**From:** Ross Anthony <ross.anthony@hbap.org.uk>  
**Sent:** 03 February 2022 13:21  
**To:** Planning  
**Subject:** Application Ref: 3/2021/1249 - Duke of York Inn, Grindleton Brow, Grindleton, Clitheroe, Lancashire, BB7 4QR

**Re: Duke of York Inn, Grindleton Brow, Grindleton, Clitheroe, Lancashire, BB7 4QR**  
**Application Ref:** [3/2021/1249](#)

Drawing Title
Existing site layout
Phasing drawing

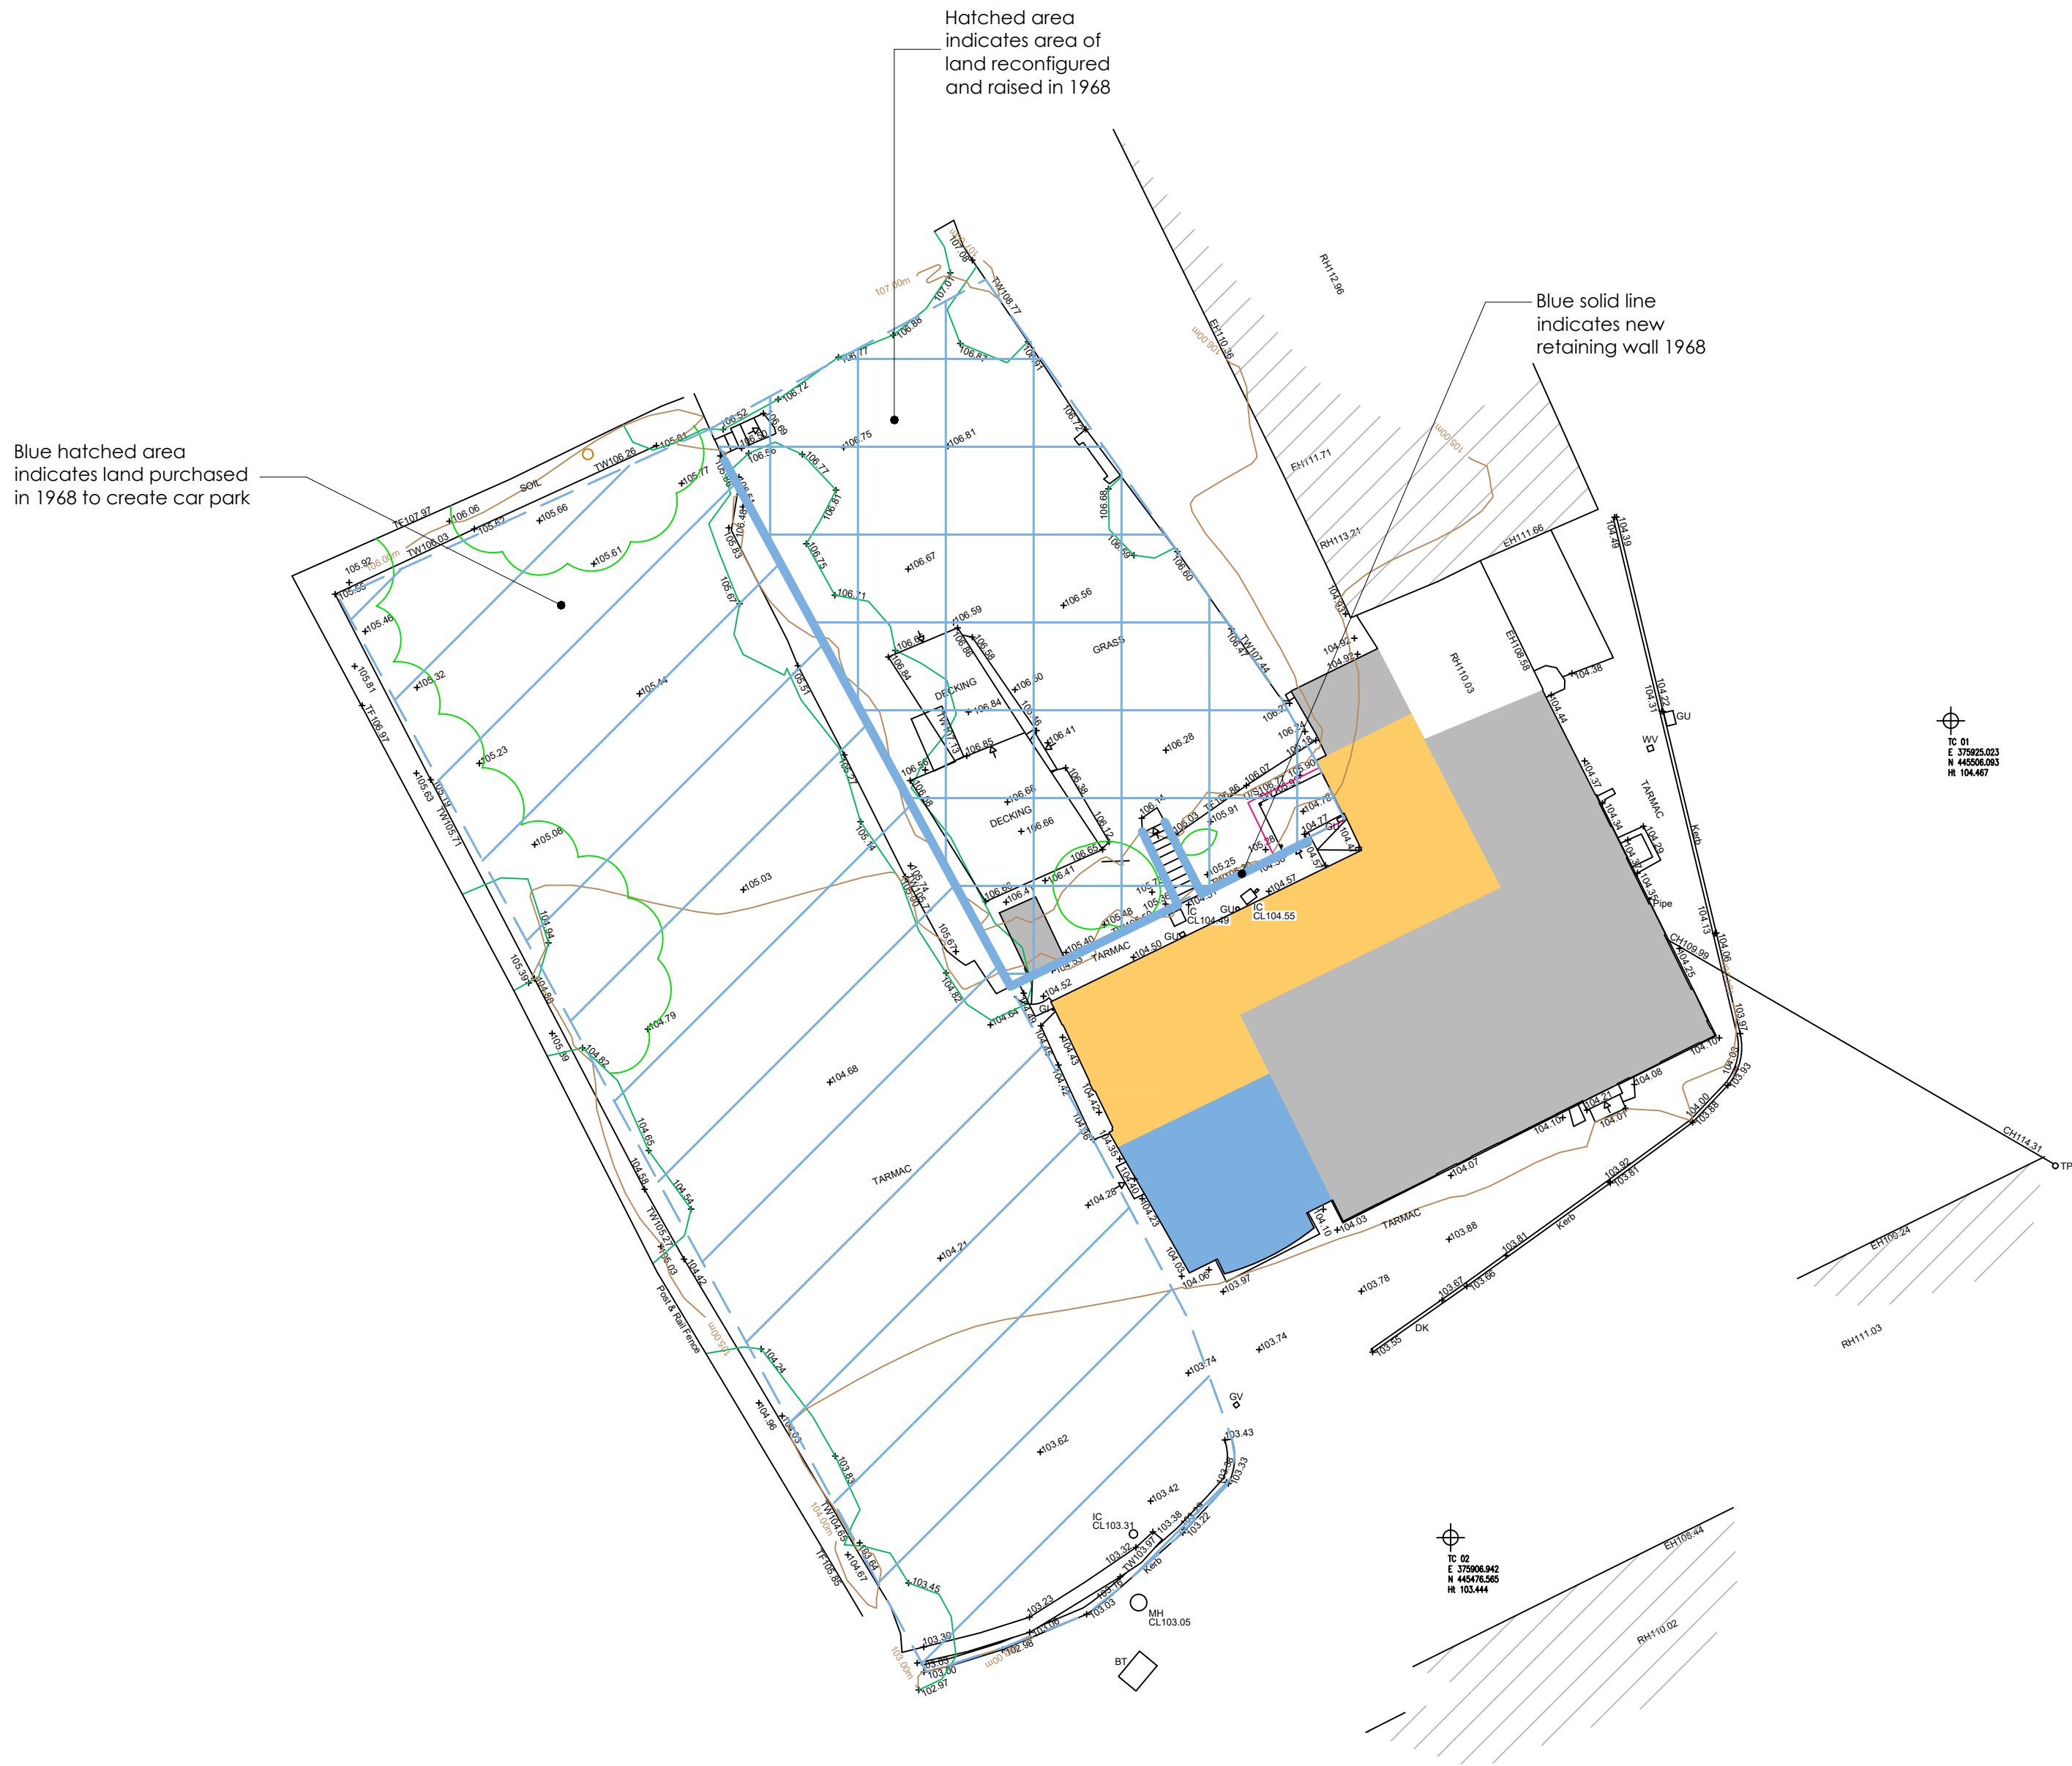
We object to the proposed 1m high stone fence to the front of the original Inn building facing Grindleton Brow and the side return to Main Street. The fence is an overly domestic feature that changes the setting of the former Inn and takes away from its historic role as a public house. We are also opposed to the creation of a bin store along the highly visible east elevation.

We would also suggest changes to the design of the new garage extension replacing the 1960s restaurant to the western end of the building. In the first instance, it is unclear why this needs to be demolished, rather than adapted for the new use. The blank wall is also highly visible to traffic entering from the west and a more active appearance would be preferable. We would also recommend further consideration be given to the use of more modern materials to ensure the garage structure is understood to be a clear addition to the building.
